From:
Sent: 11 August 2026 19:01
To: DC Admin
Subject: Fwd: Final comment - Planning application 2026/91900 – Supplementary objection regarding access to No. 68
Attachments: IMG_20250901_080654.jpg

Proposed Site Plan

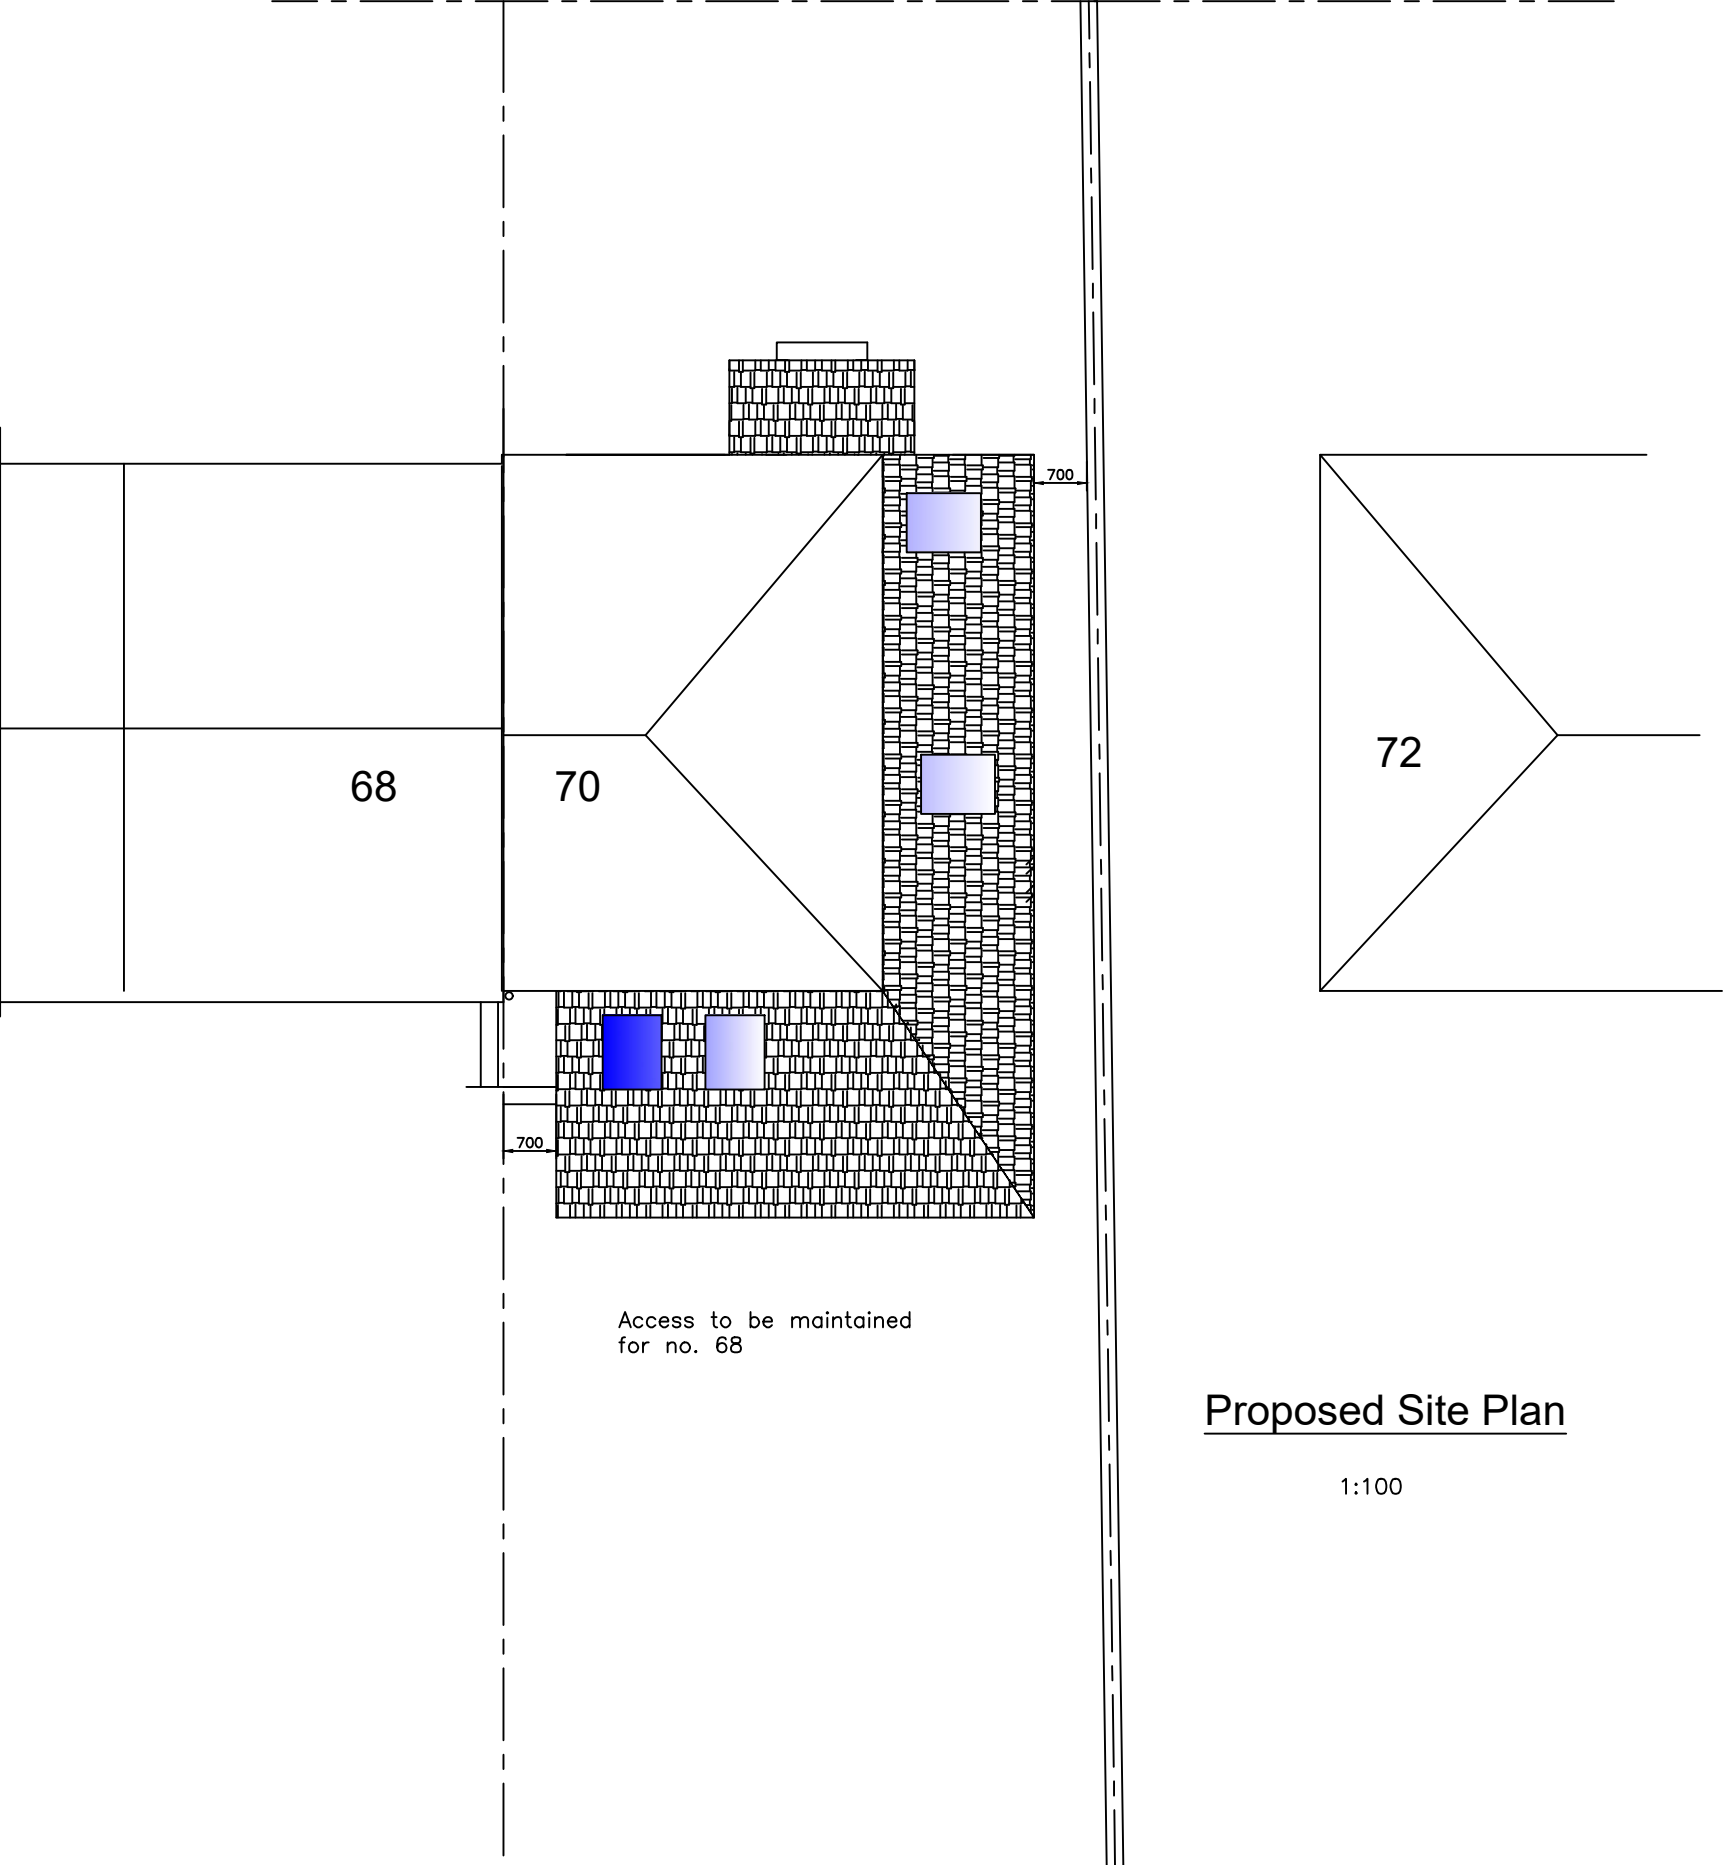
The proposed extension would reduce this access further, creating a narrow corridor that would make maintenance and drainage management significantly harder. I ask that this impact on amenity and practical access be considered as part of the assessment.
